Date: 28-Nov-2024
Our Ref: 2024/93041

**Discharge of details reserved by condition 11 (validation report) on previous
permission 2021/92255 for erection of 5 dwellings with associated access and
demolition of existing extensions to commercial building
The Old Tannery, 224, Spen Lane, Gomersal, BD19 4PJ
Application Number: 2024/93041**

- Phase 4: Validation report - C3920/24/E/5955

Photographs

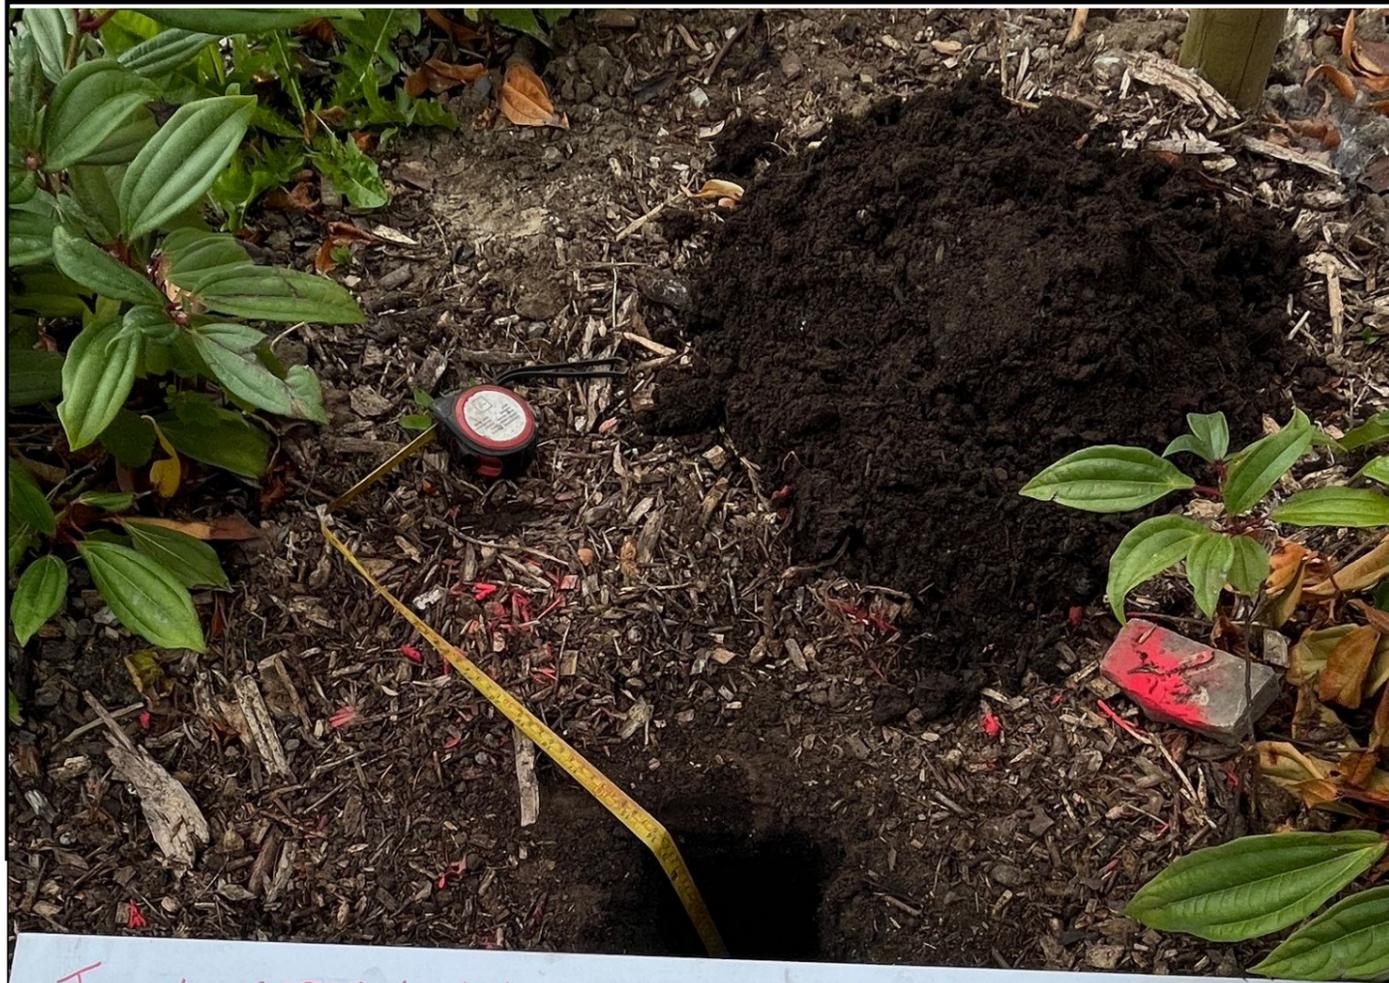
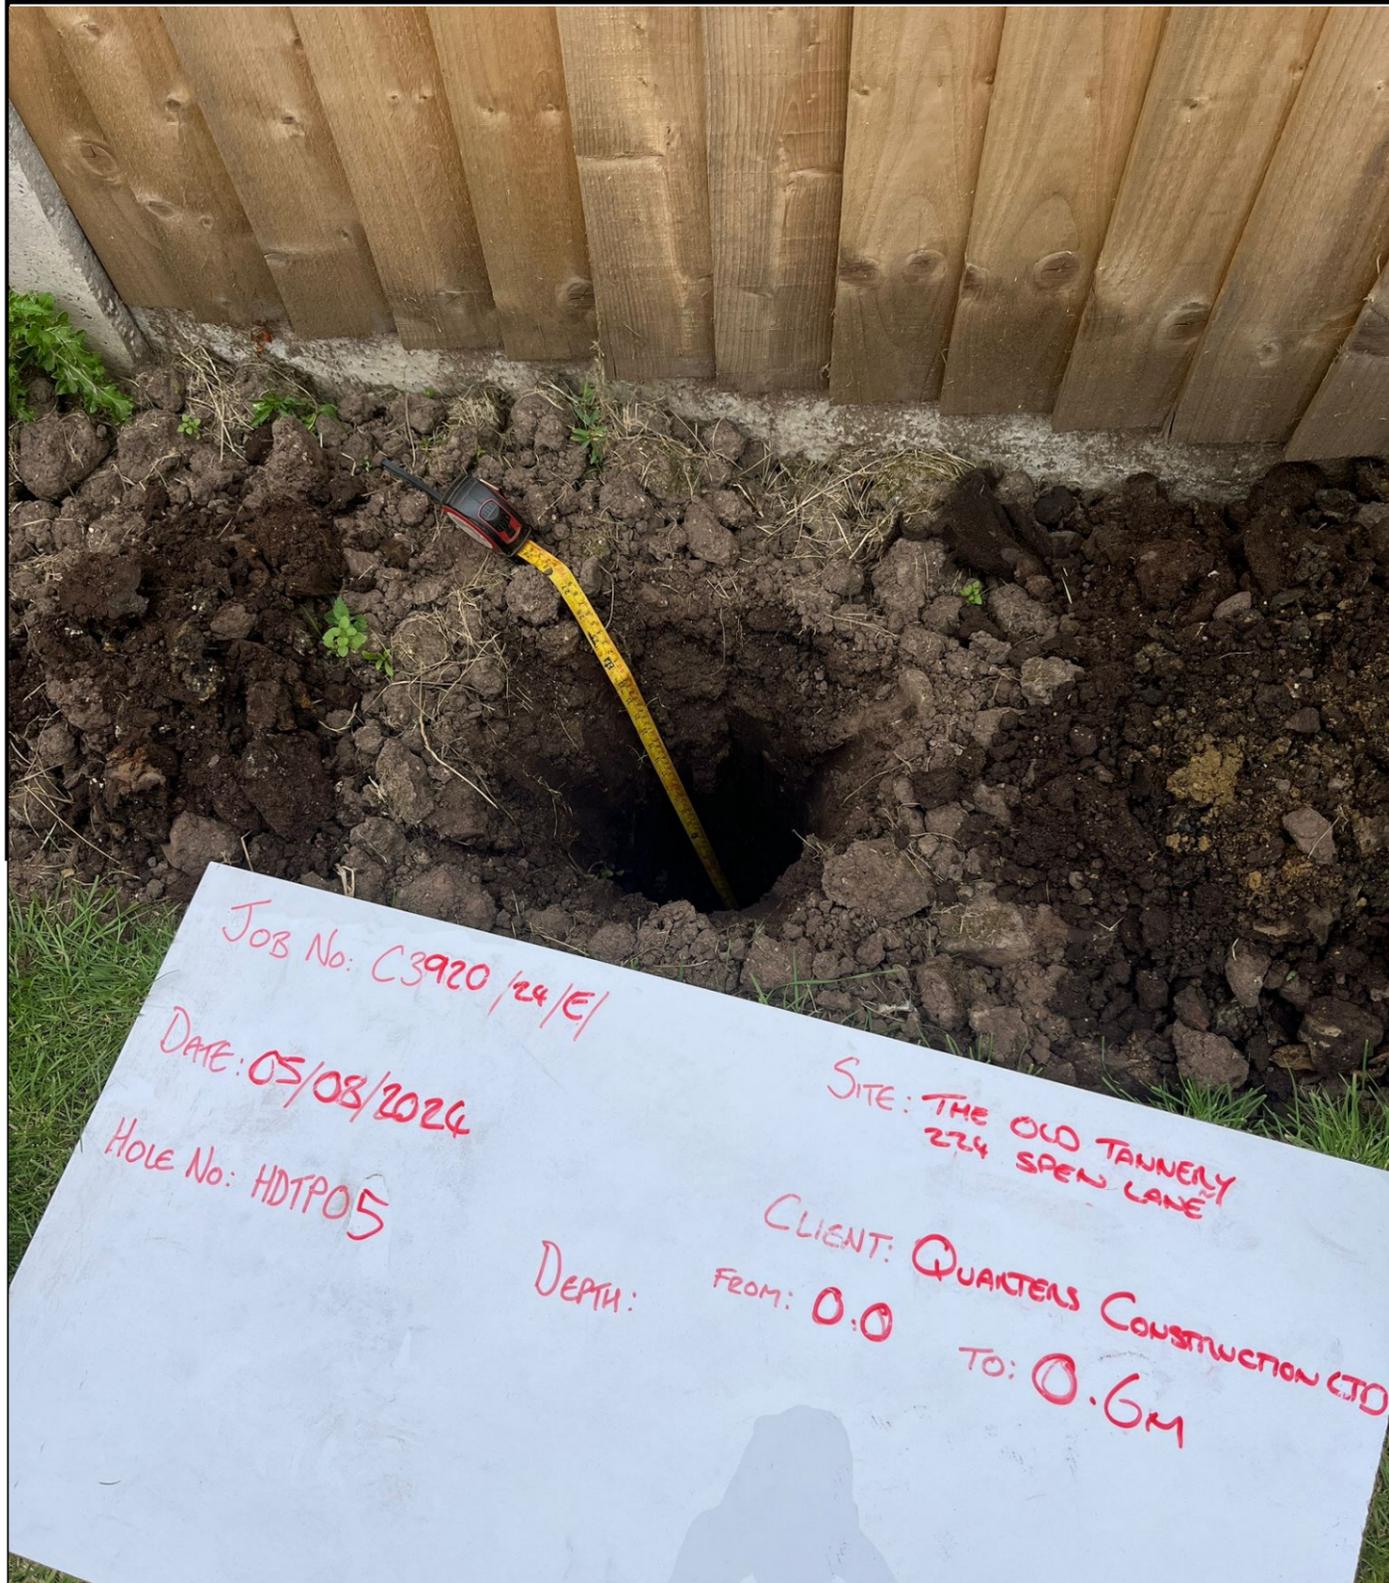
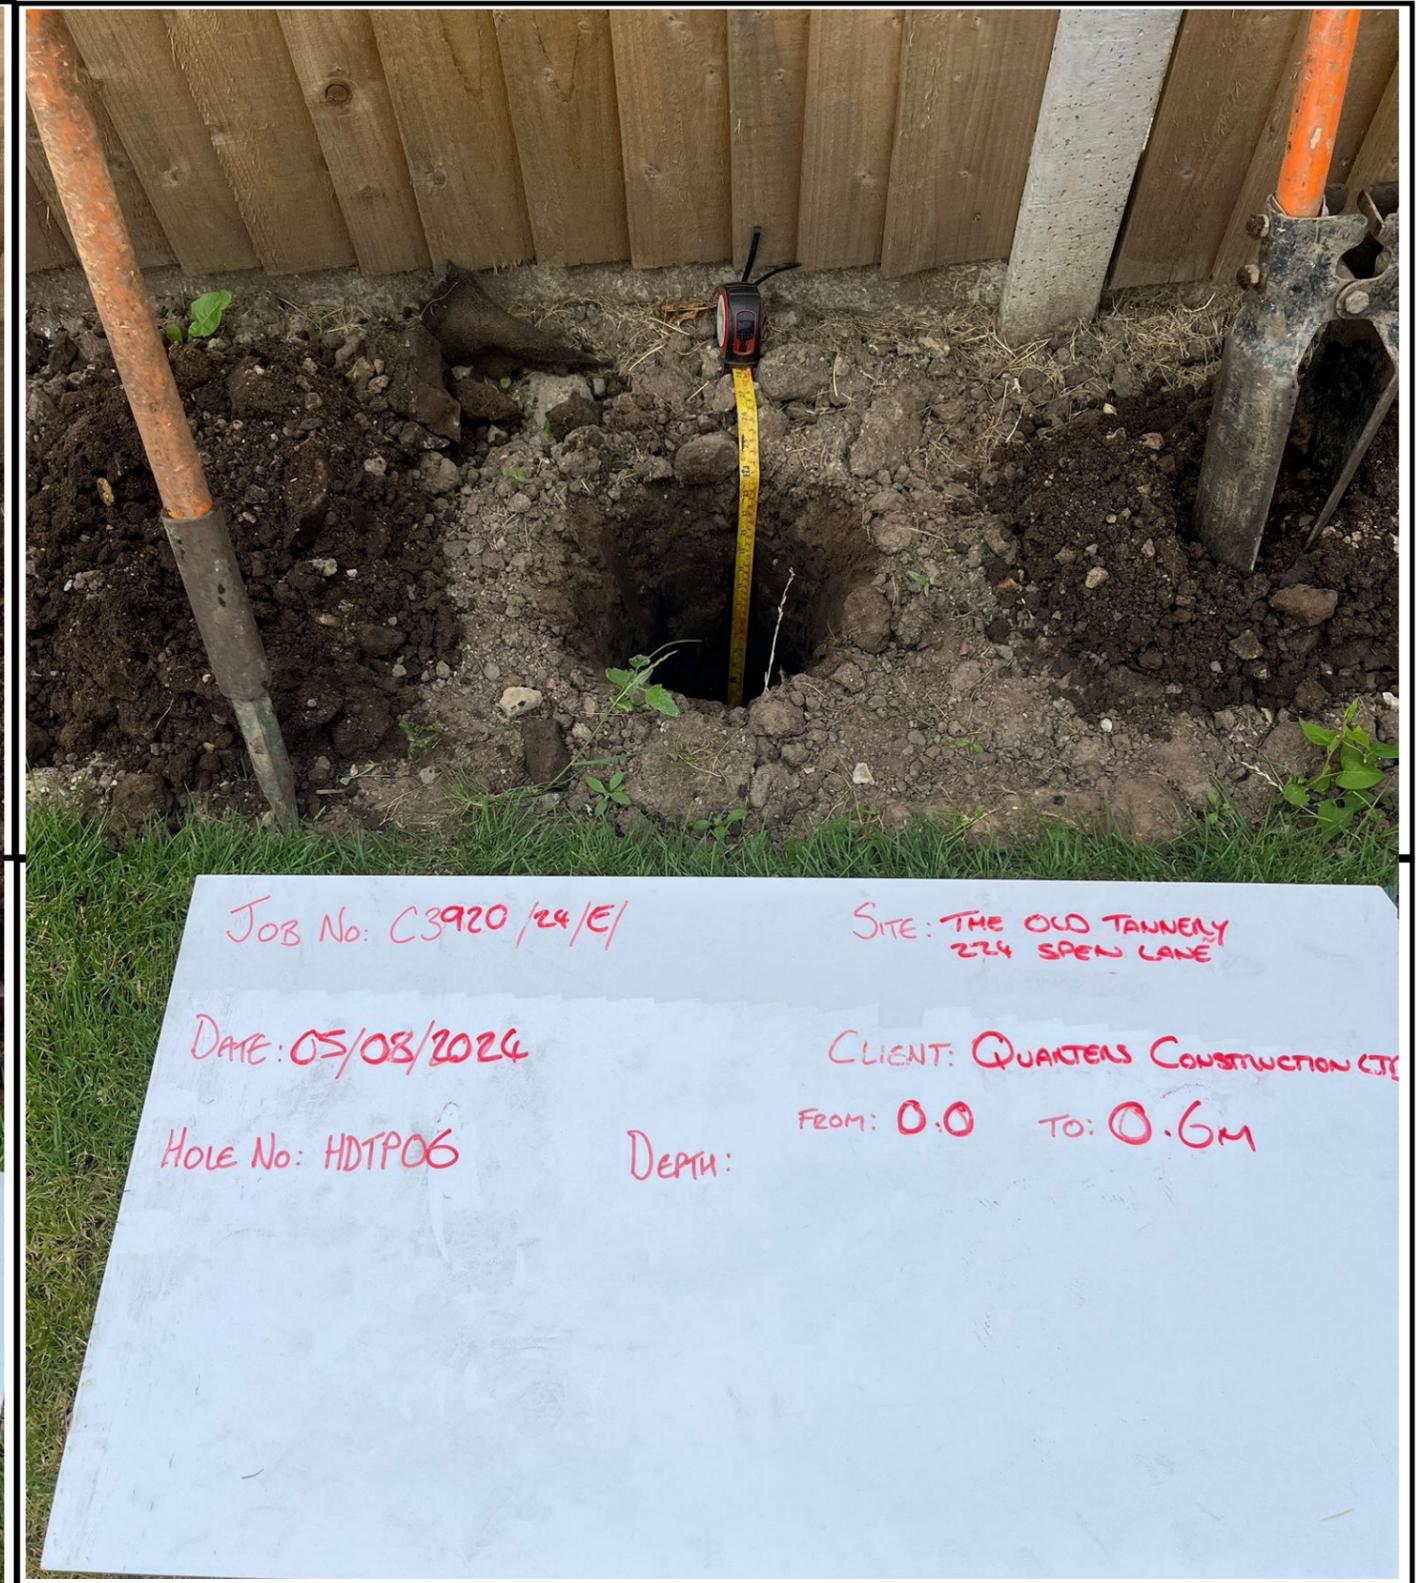
- The agreed clean cover system included a geotextile membrane. However, no membrane is reported in the trial pit logs or evidenced in the photographs. Further clarification on this point is necessary.
